Arun District Council
Arun Civic Centre
Maltravers Road
Littlehampton
West Sussex BN17 5LF
Planning & Building Control General Enquiries
Tel: (01903) 737756 Fax: (01903) 730442
Dx: 57406 Littlehampton
Minicom: 01903 732765
e-mail: planning@arun.gov.uk
website: www.arun.gov.uk/planning

Application No: FG/211/21/PL
Site Address: 2 The Poplars Ferring BN12 5QL
Description of works: Demolition of existing building and replacement with 1 No dwelling (resubmission following FG/129/21/PL). This site is in CIL Zone 4 and is CIL Liable as new dwelling.

Thank you for your internet representation made on 29th December 2021 which has been recorded as an objection with the comments as follows:

DRAWING TITLE	PROJECT NO.	DRAWING NO.
Proposed Elevations / Section AA	21001	GE.01
STATUS	DATE	REVISION
PLANNING	11.2 1	-

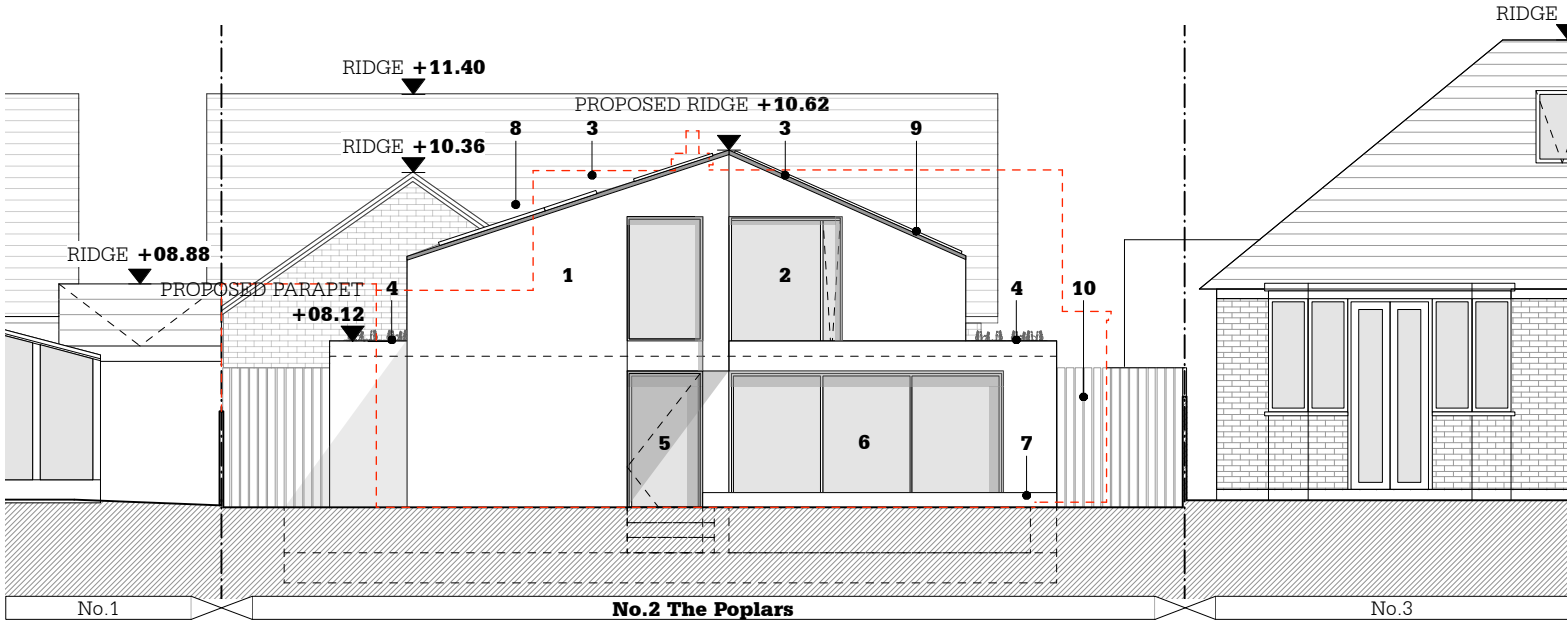
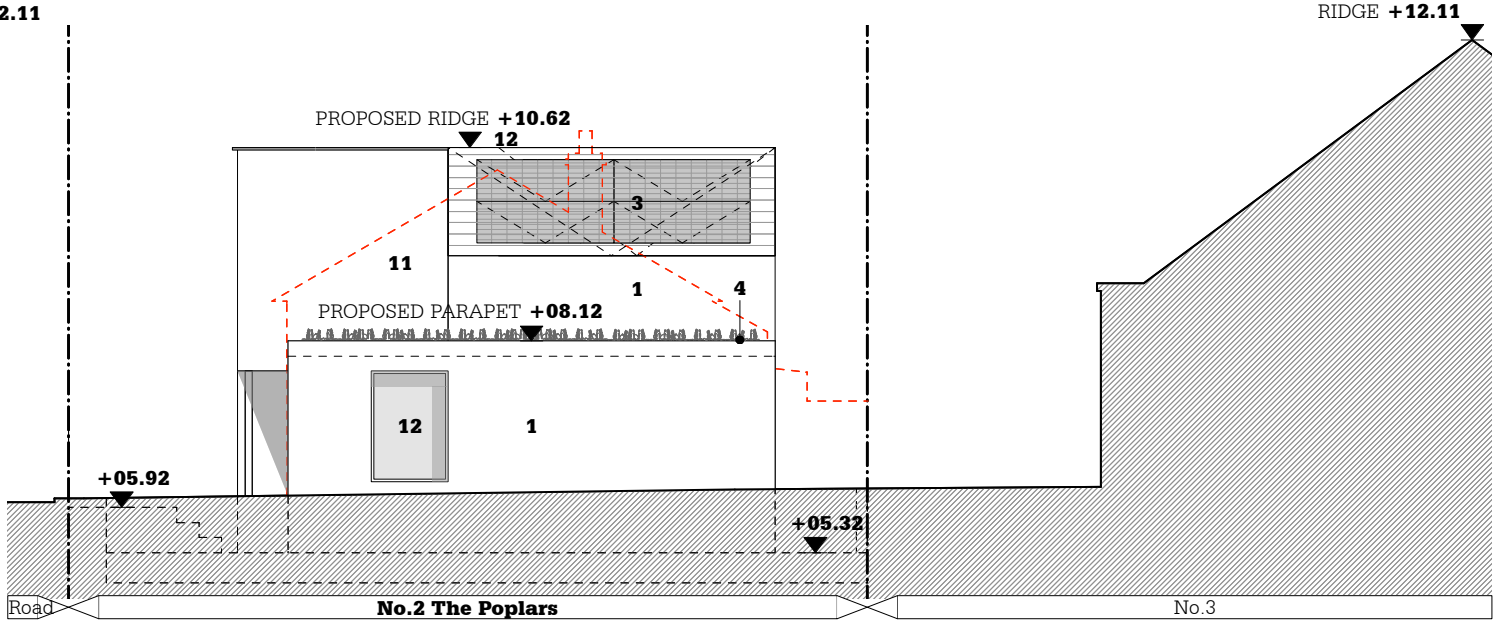
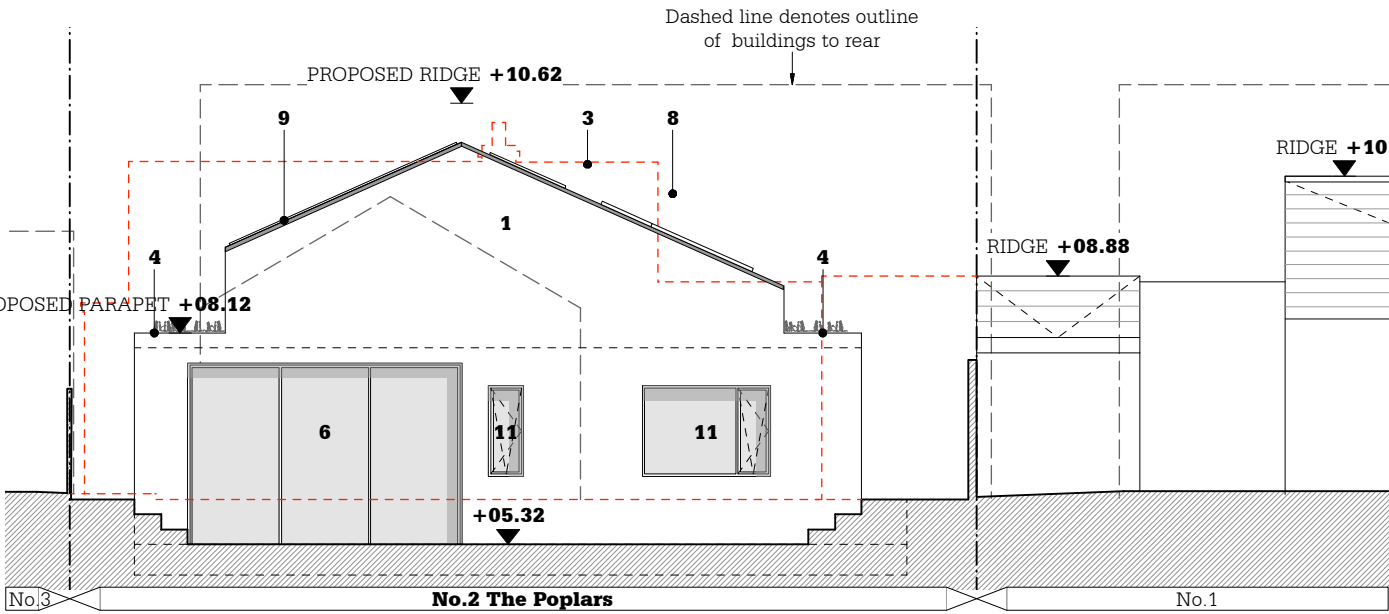
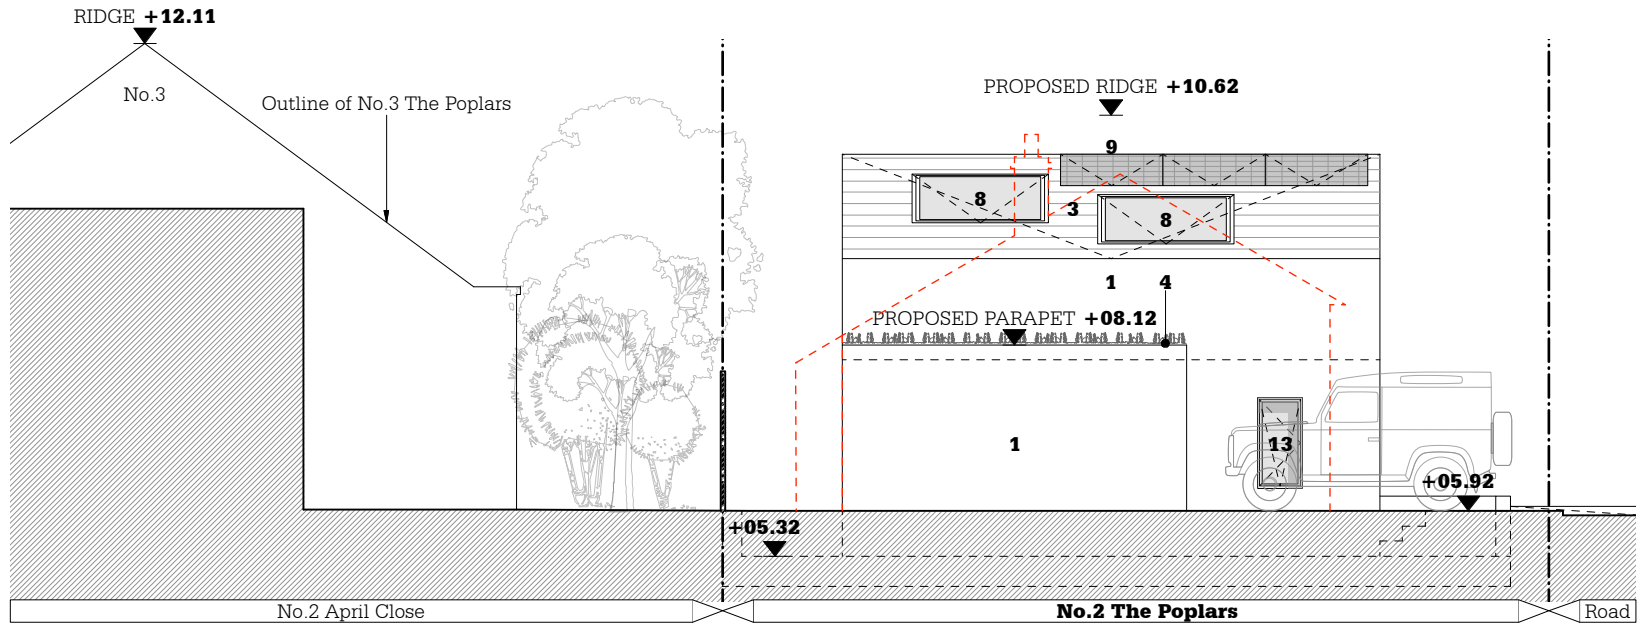
It is still two storey, still incongruous with the rest of The Poplars and still has a parapet which cannot be guaranteed will not be used as a balcony.
